DEVELOPMENT REVIEW BOARD--SPEED MEMO

**CITY OF ALBUQUERQUE
PLANNING DEPARTMENT
June 4, 2008
DRB Comments**

PROJECT # 1007306

RE: Lot 8, Los Mochos; Lot 11-B, Jim Moore Realty Addition #3

**PLAT OF  
LOT 8-A  
OF  
LOS MOCHOS COMPOUND  
WITHIN  
TOWN OF ALBUQUERQUE GRANT  
PROJECTED SECTION 7, TOWNSHIP 10 NORTH, RANGE 3 EAST, N.M.P.M.  
CITY OF ALBUQUERQUE  
BERNALILLO COUNTY, NEW MEXICO  
MAY, 2008**

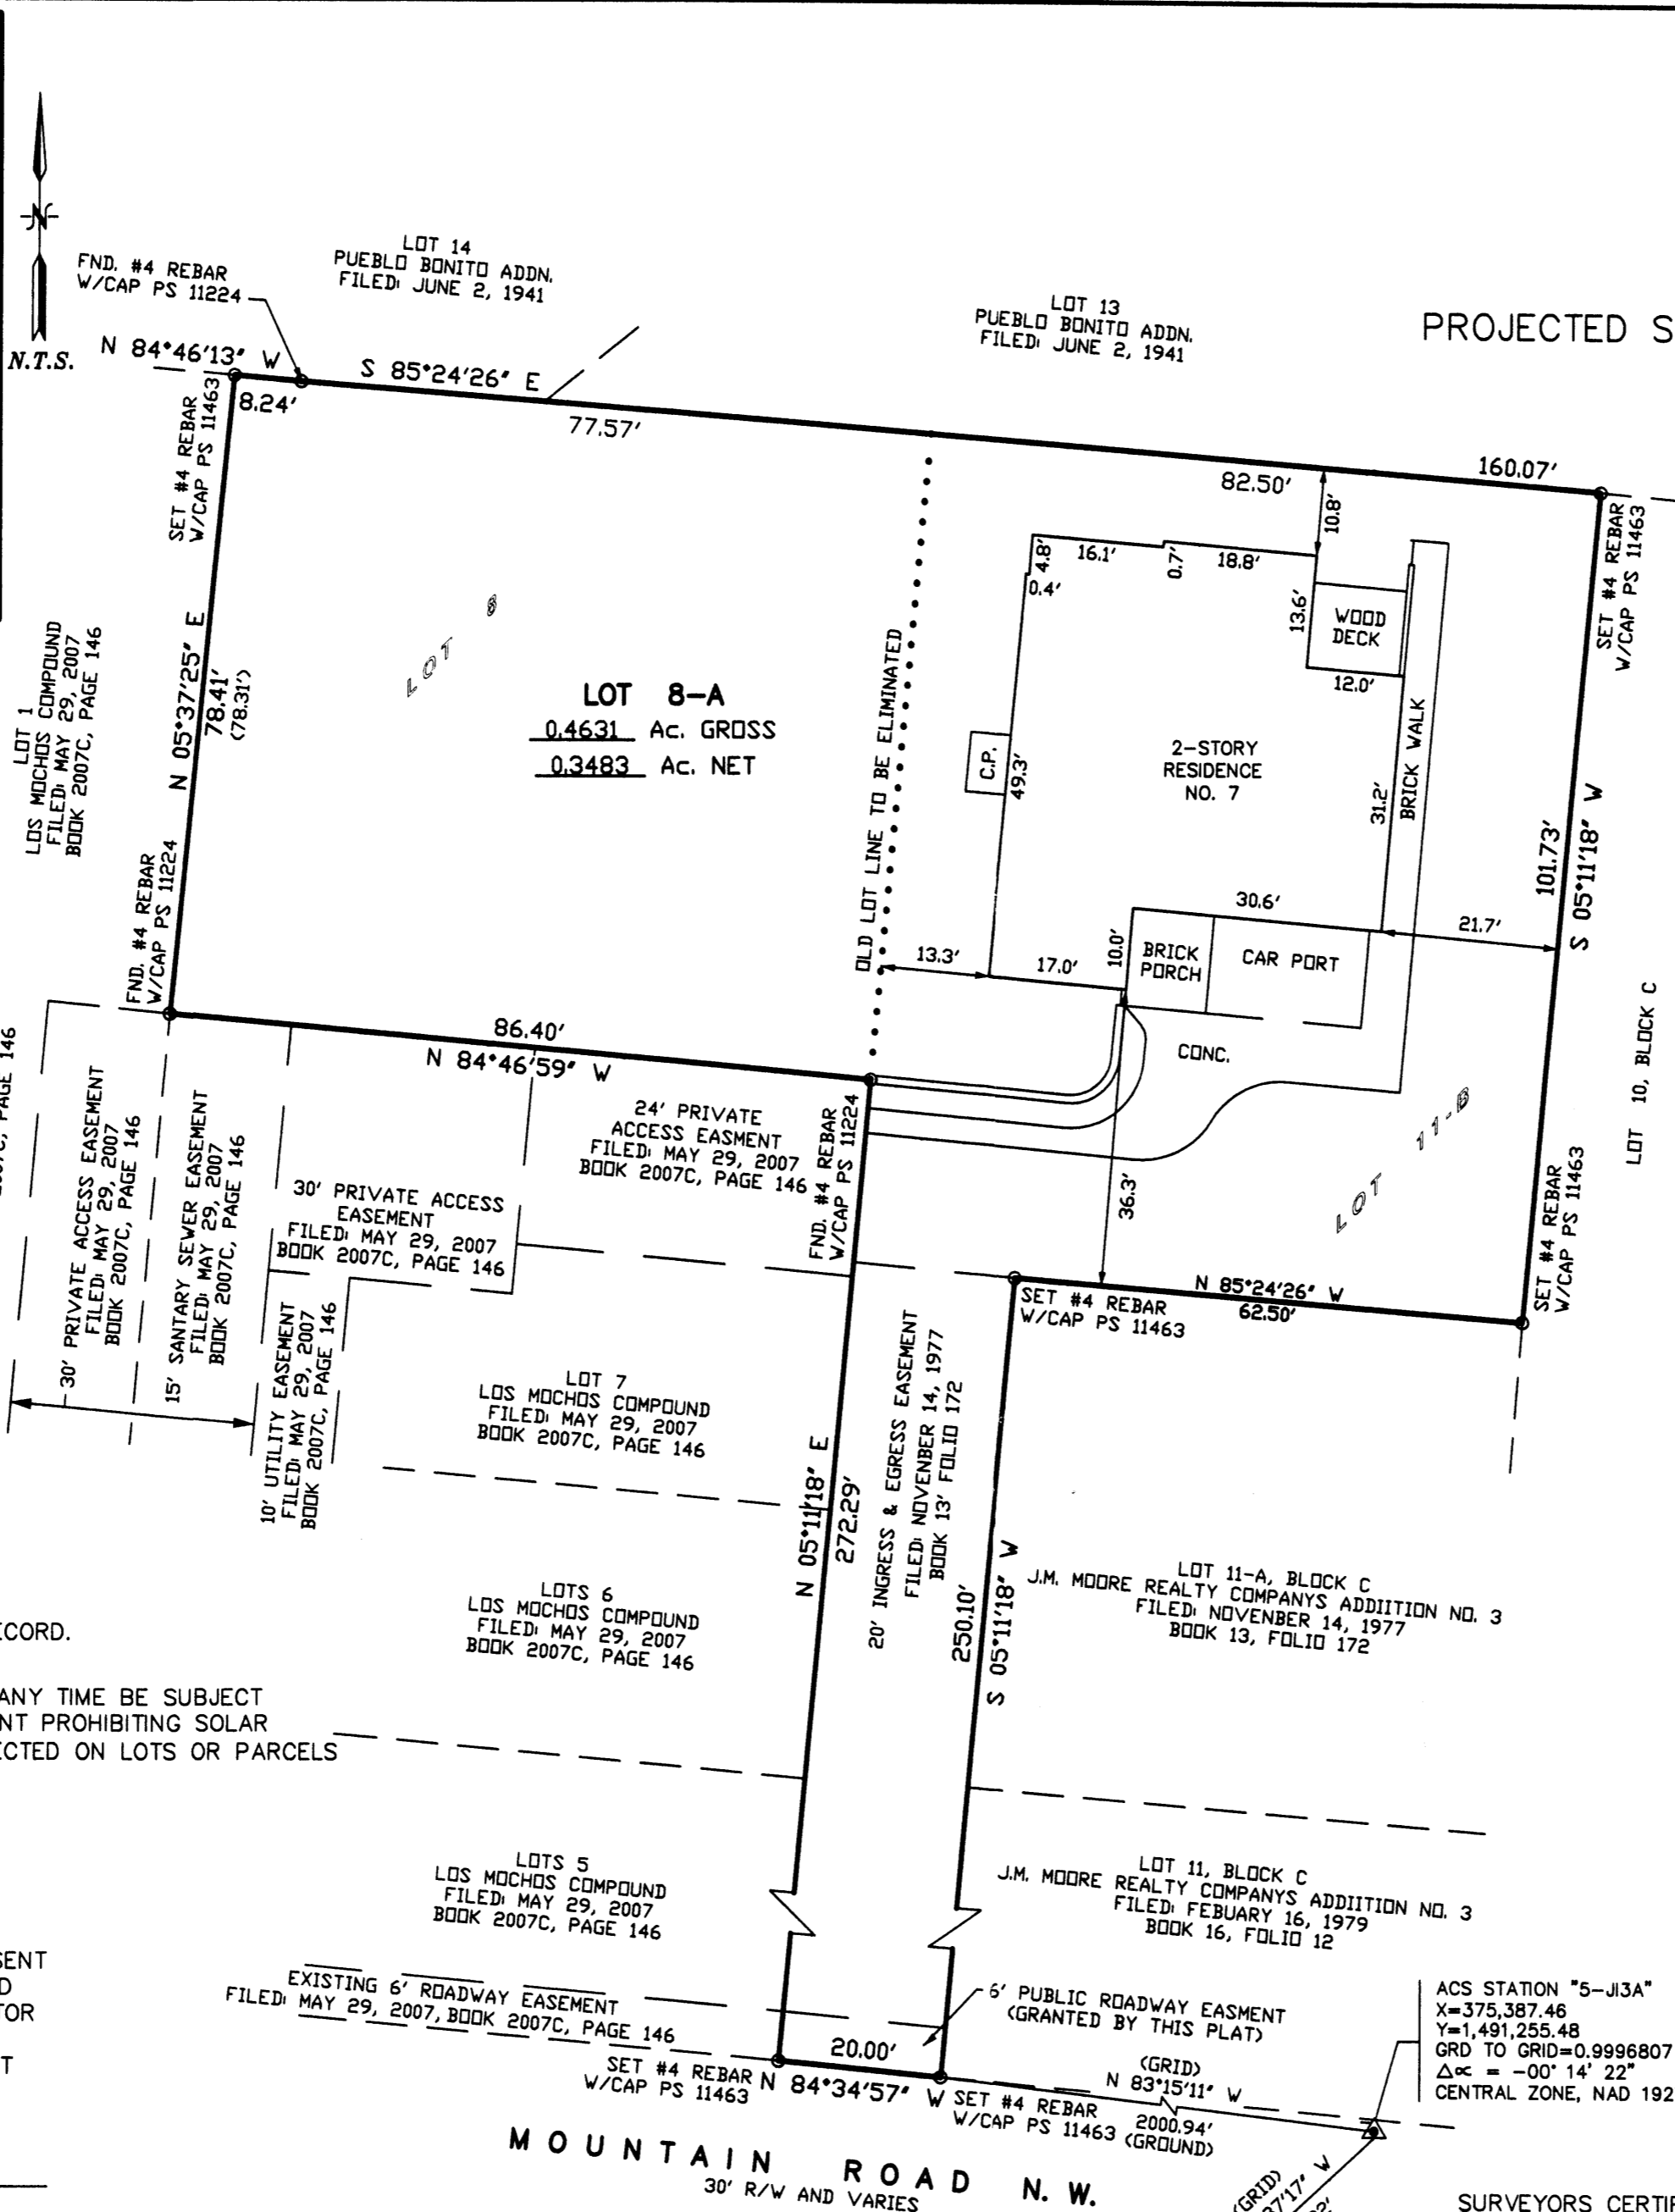
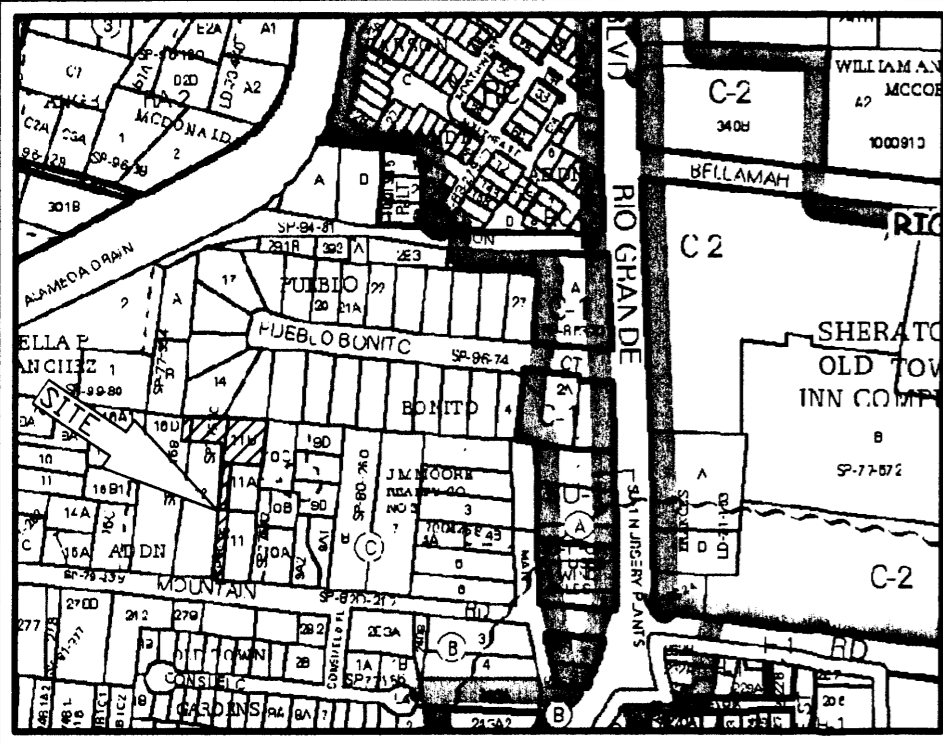
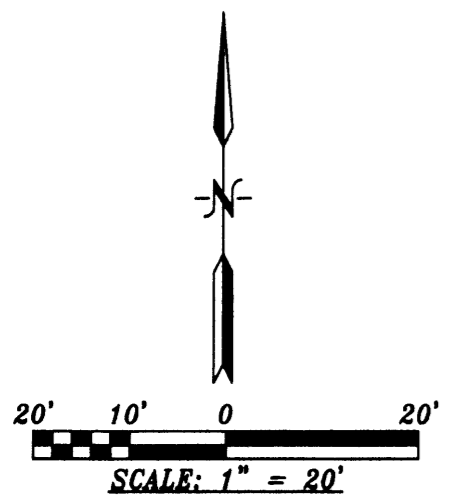
Filing references on the plat drawing need to include letter prefix (e.g. B13, and B16). The 1979 plat (B16, folio 12) shows that Lot 11 as the underlying owner of the Ingress and Egress Easement, not Lot 11-B; this is also reflected on AGIS and Assessor's data.
